Woolworths

74 Edinburg Road,
Marrickville NSW -
Warehouse Facility

**Access Review -
Draft**

14th August 2020

Figure 9 Extract of ground floor plan

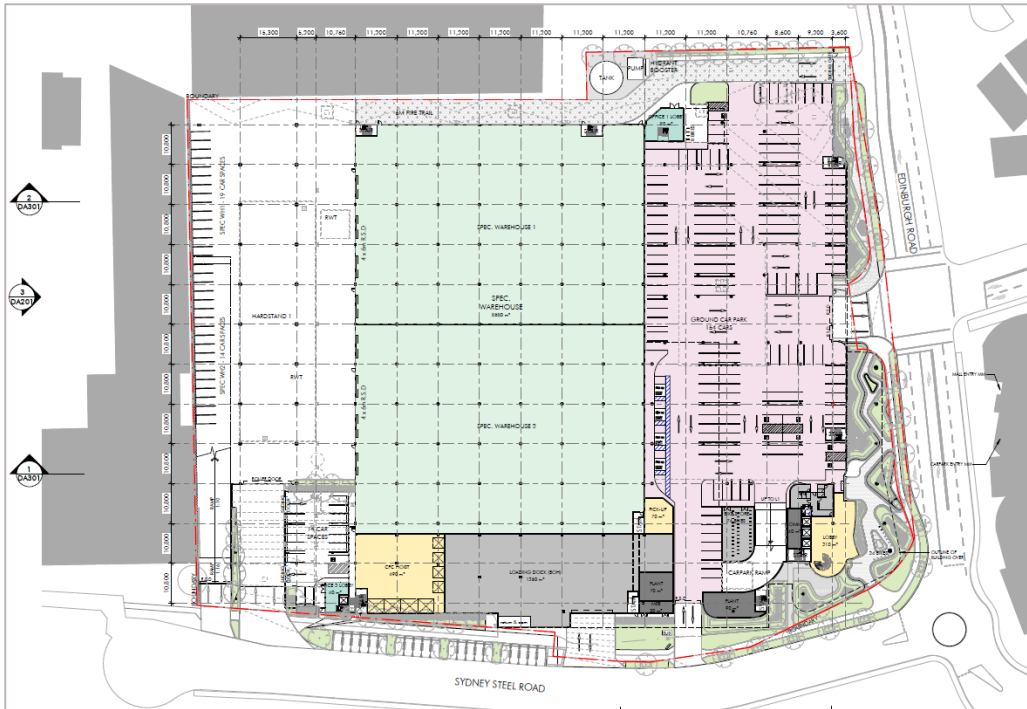
- Wheelchair passing bays (1800mm width x 2000 length) when a direct line of sight is not available and are to be provided at 20m max. intervals along access-ways. Currently, this requirement has not been achieved. A passing bay on the ground floor is required where there is no a direct line of sight.

Provide a passing bay where there is no a direct line of sight.
